Our Ref: D2016/121748

**Springvale Water Treatment Project (SSD 7592)
Review of Environmental Impact Statement**

Attachment 1: WaterNSW's comments on the EIS for the Springvale Water Treatment Project (SSD 7592)

Figure 5-7 Monitored daily LDP006 discharges

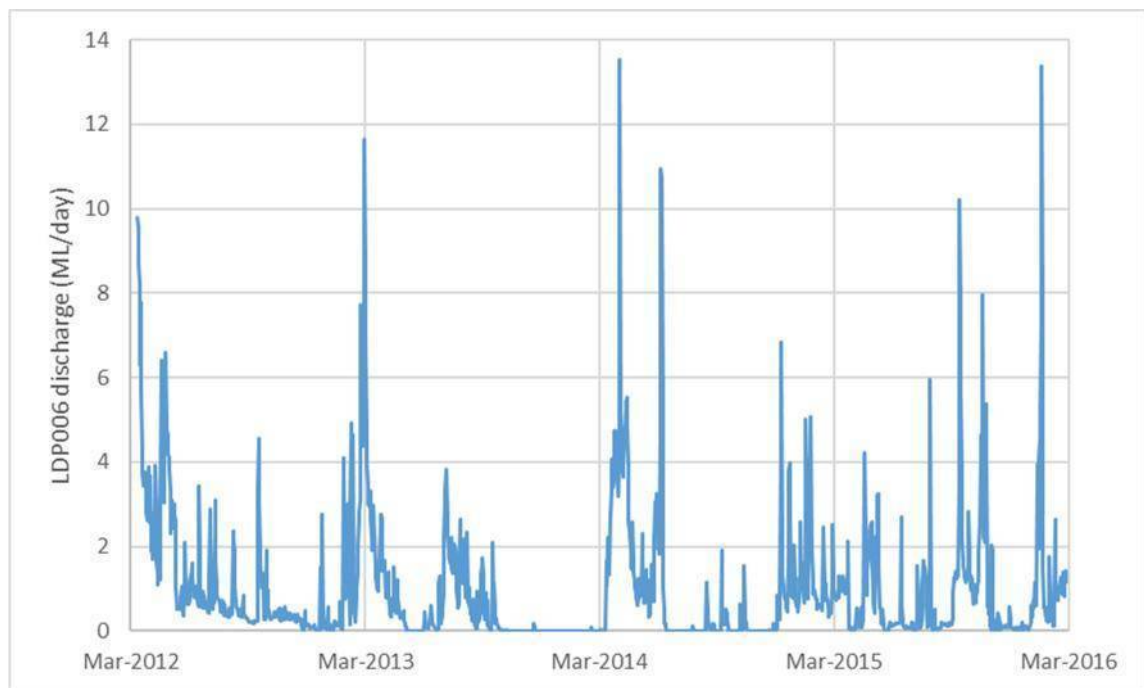
- The discharge volumes from the SCSS at LDP006 are reported on average to be 1.29 ML/day, with historical ranges between 0-14 ML/day. WaterNSW understands that current discharges at LDP006 are close to 4-5ML/day. The correct volume should be identified and water and salt balance modelling should be updated accordingly.

- LDP006 discharge salinity is currently more than 3000 $\mu\text{S}/\text{cm}$. It is likely that the salinity of existing discharges from LDP006 may increase due to disposal of SWTP solids at the REA at the SCSS. There may also be other potential water quality impacts from residue materials being deposited at the REA which have not been addressed in the EIS. The potential surface water and groundwater quality impacts should be thoroughly assessed.
